FAO: Economic Development and Planning
Planning Application No: 3/2021/0661

28th February 2023

IMAGE 2: HGV TRIAL 11th NOVEMBER 2020 4 AXLE RIGID WEST BRADFORD RD (SOUTHBOUND) WADDINGTON & W. BRADFORD PRIMARY SCHOOL

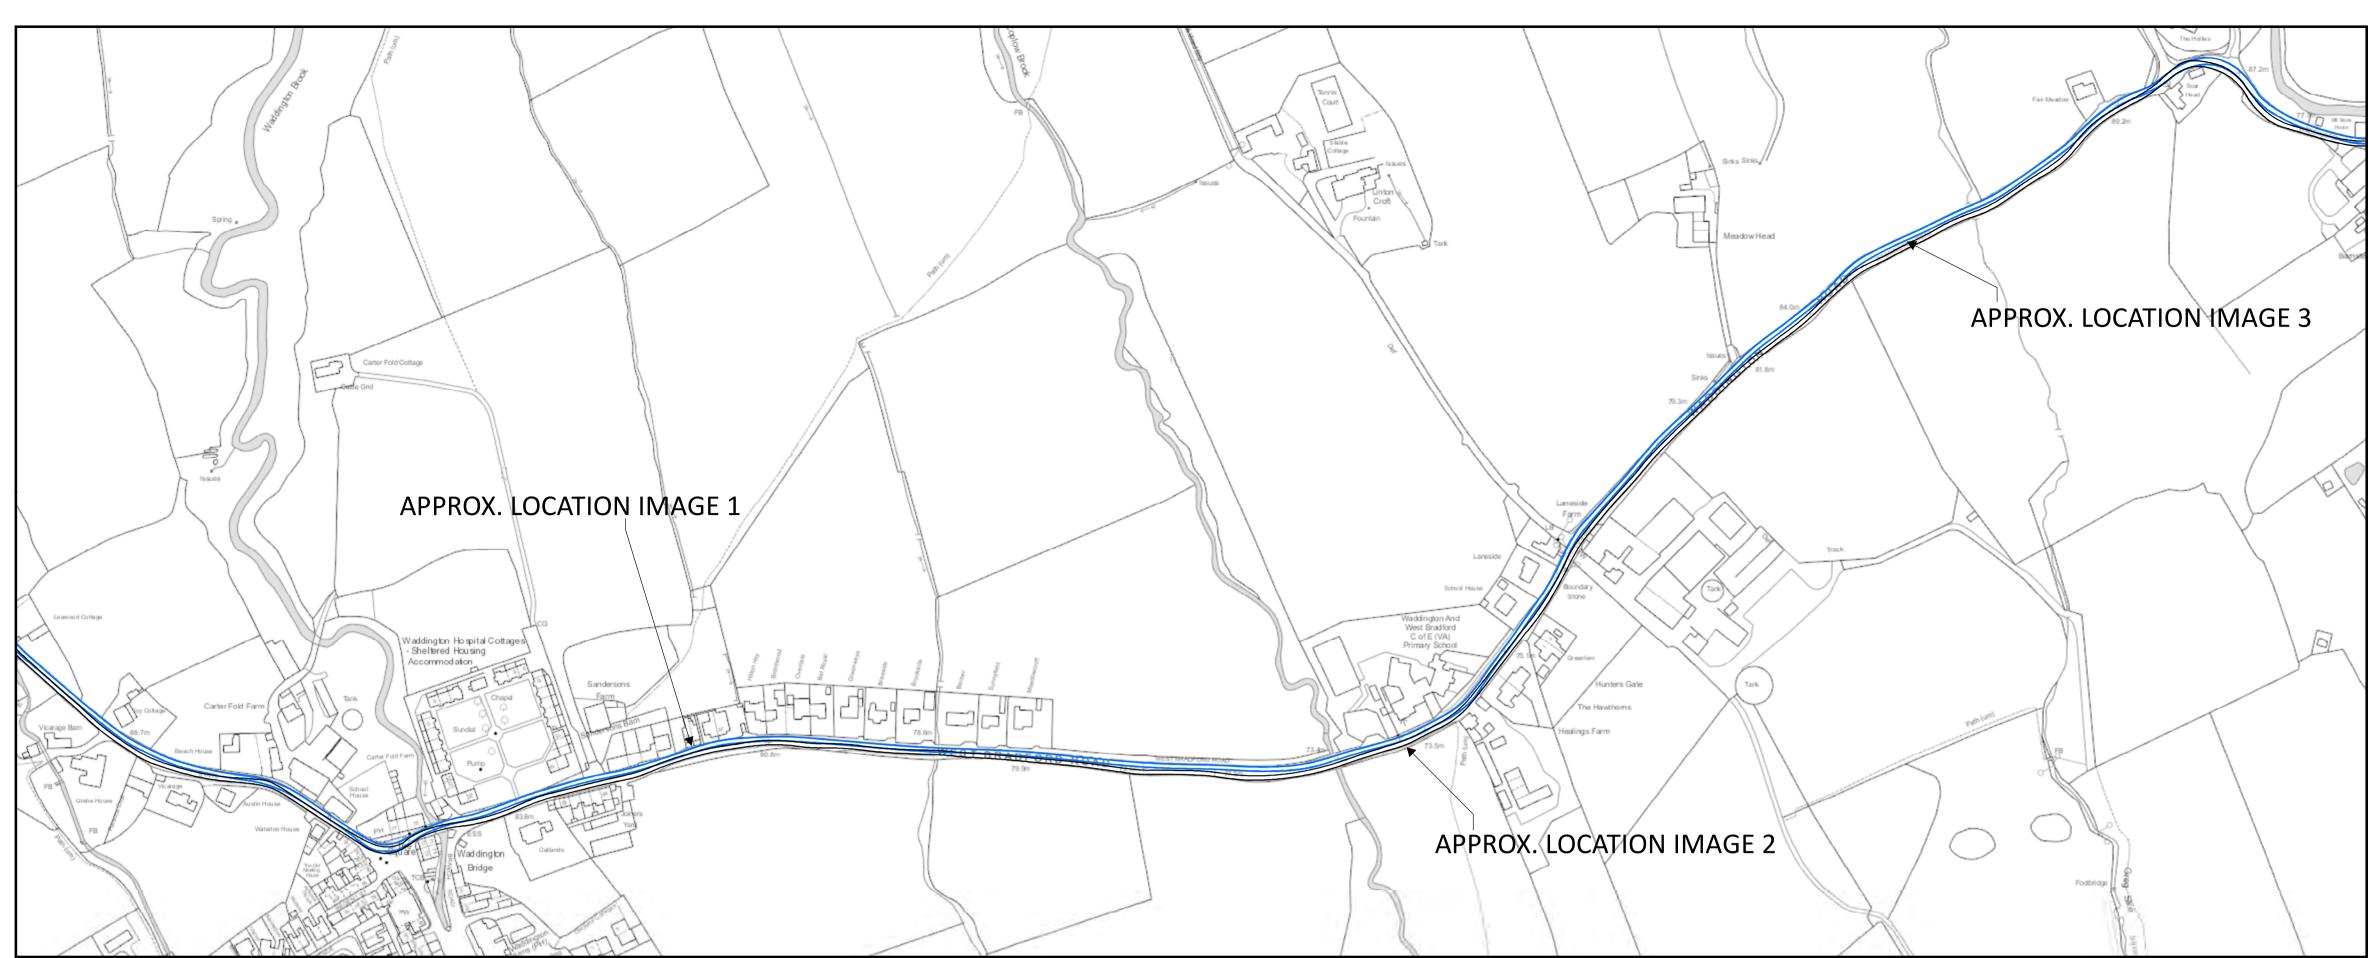
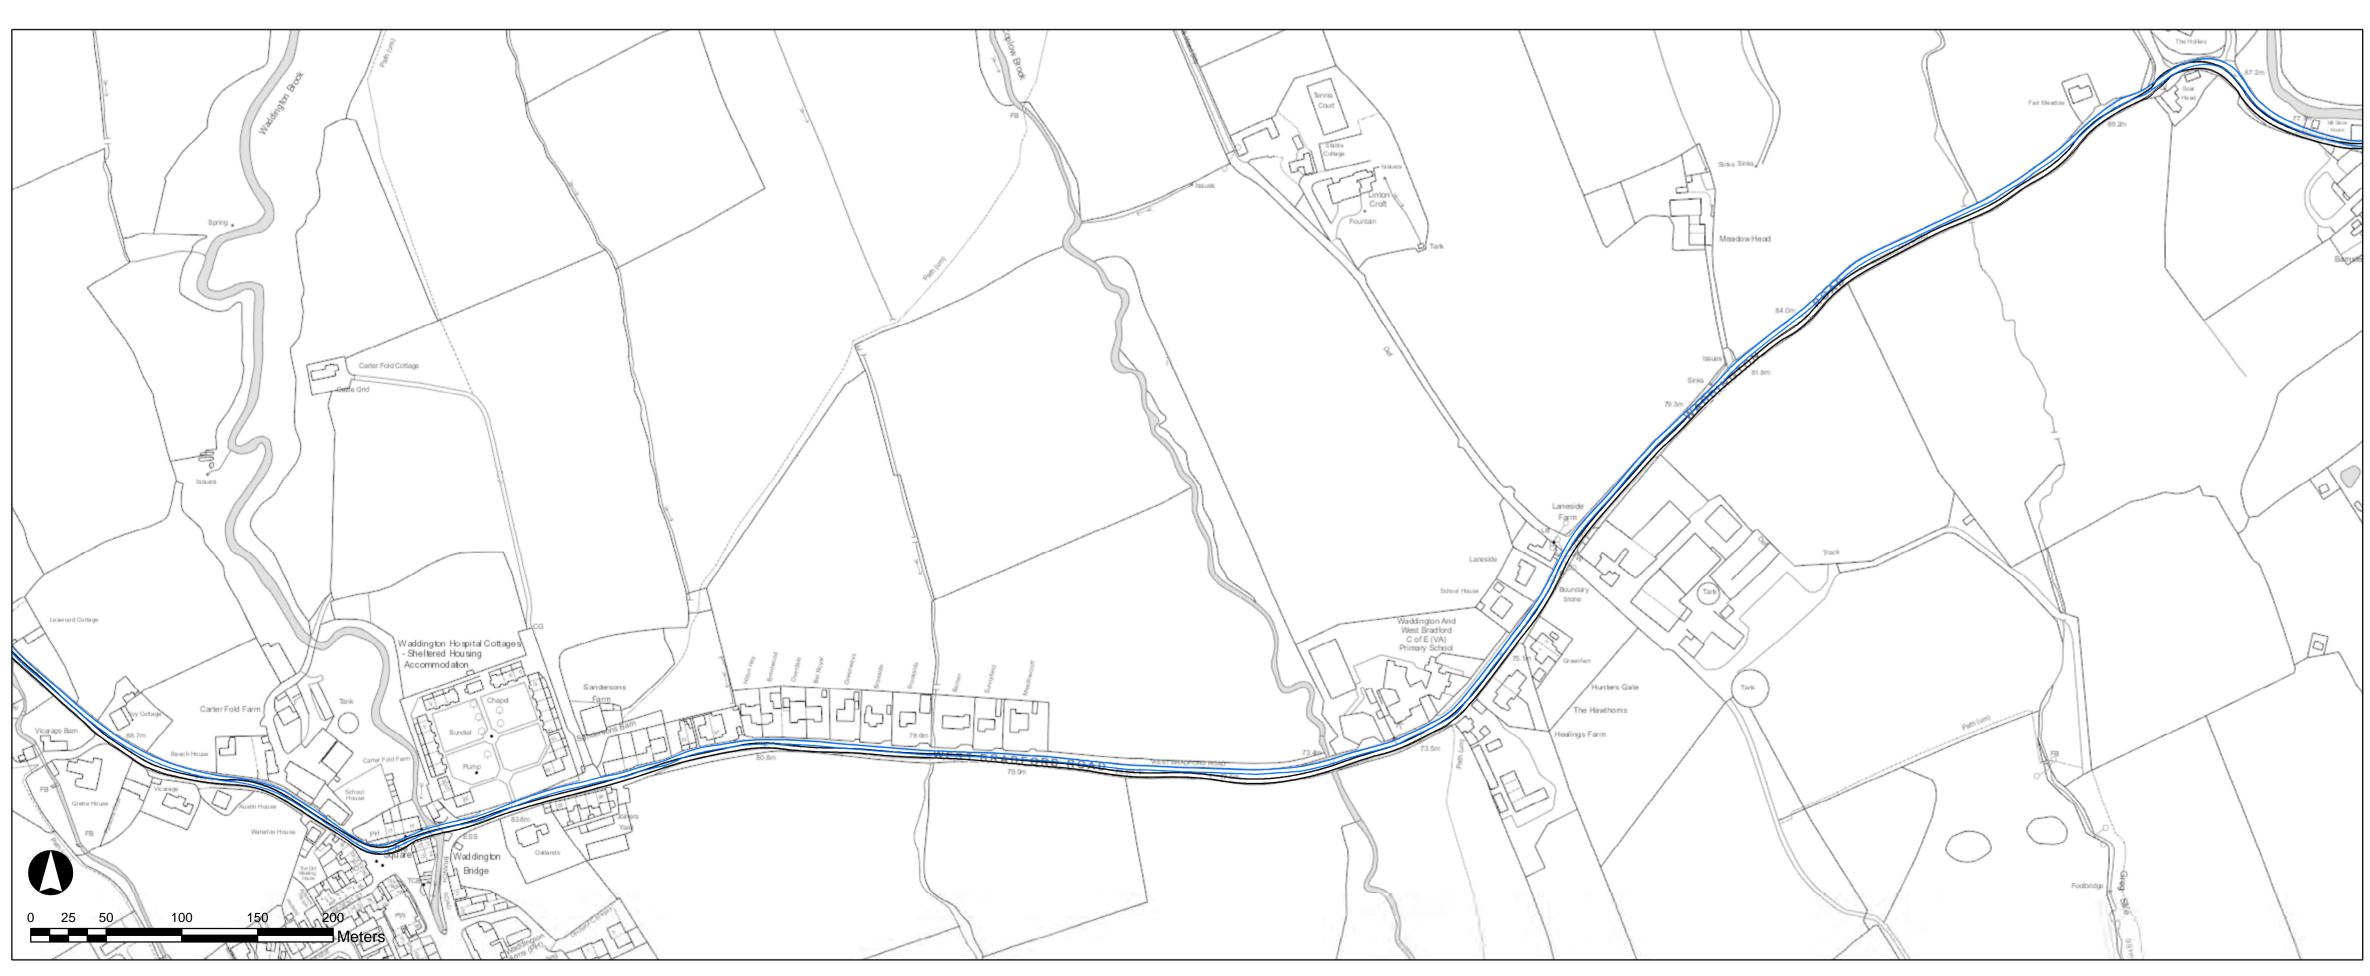
- a) The road widening scheme is limited to the area between No 70 and Brantwood on West Bradford Road (the Road). Yet the LCC letter confirms that the road between Berner and Greenways, "is extremely tight" and there is "no factor of safety".

- b) The removal of vegetation to give clearer lines of sight along the Road, will encourage higher speeds from all road users. Currently the existing speed limits are generally ignored this will only increase. If proposals to proscribe lower speed limits are implemented, greater checks and management will be required as risk of accidents caused by speed will only increase.

- d) Damage will also be caused to southern edge of the Road where currently there is no kerb or provision for water drainage.
- e) Whilst provision is made to avoid working at school arrival and

departure times, traffic and parking issues relating to the school is continuous throughout the day, and the highest priority must be given to ensure the safety of schoolchildren.

- a) The road widening scheme should be revised for the Road, to ensure safety of all users and residents. Also, to ensure speeds of all vehicles are limited to 20 mph.
- b) Further study is required to understand the need to upgrade and maintain the Road to levels required for safe passage of all vehicles.
- c) The provision of a CarPark/Pick Up/Drop Off area, near the school would make it easier for all parties and enhance the safety of the school children.
- d) The proposals for traffic flows through the centre of the village should be reconsidered and redrawn to ensure safety of residents, other road users, and property.
- e) When finalised the applicants should provide detailed plans to residents, explaining how they intend to minimize disruption and ensure the safety of all residents and their property.

IMAGE 2: WADDINGTON PRIORITY PASSING/TRAFFIC CALMING

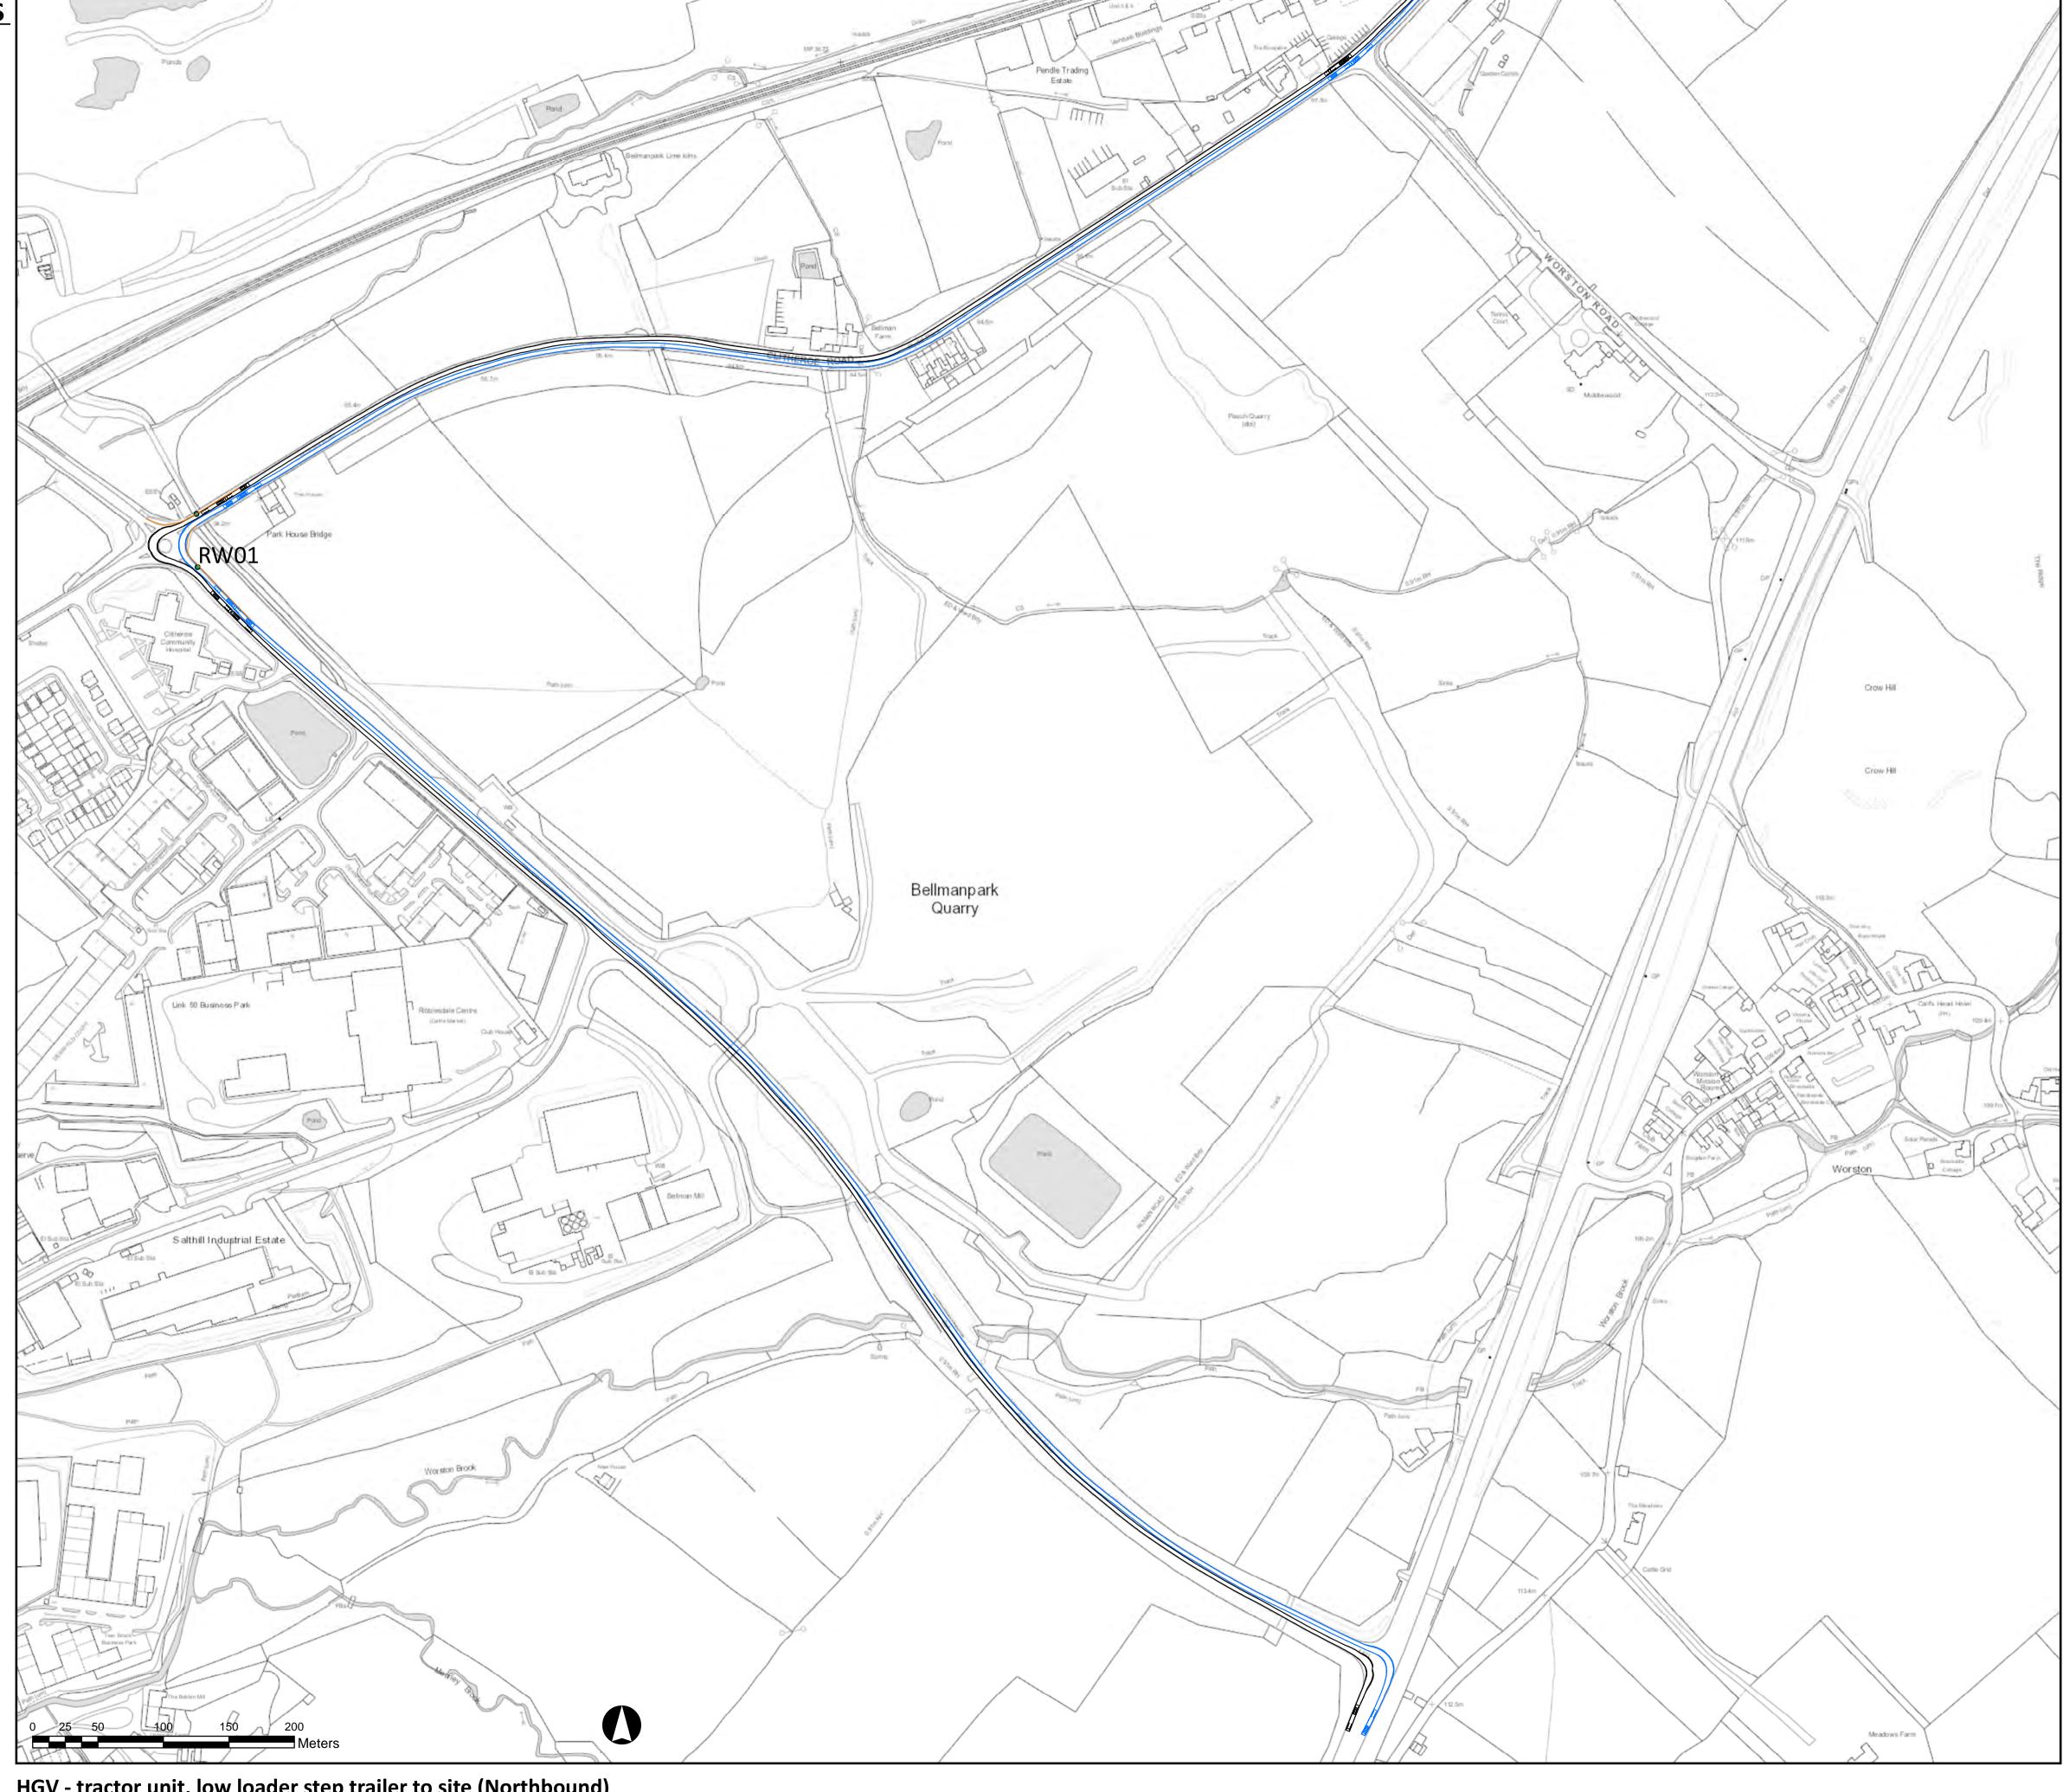
- f) The proposals of traffic flows from the Almshouses to the junction with Slaidburn Road appear to be ill considered and lacking in detail as to how the passage of HGV's through these narrow areas will be achieved without causing damage to property.
- g) In addition the safety of other road users e.g. cyclists, pedestrians needs further consideration, providing specific safe areas/lanes for their passage through the area.
- h) Residents in the village must be aware of plans to control the noise levels, minimise the loss of light, and control and clean the dirt and pollution that will arise in the village.
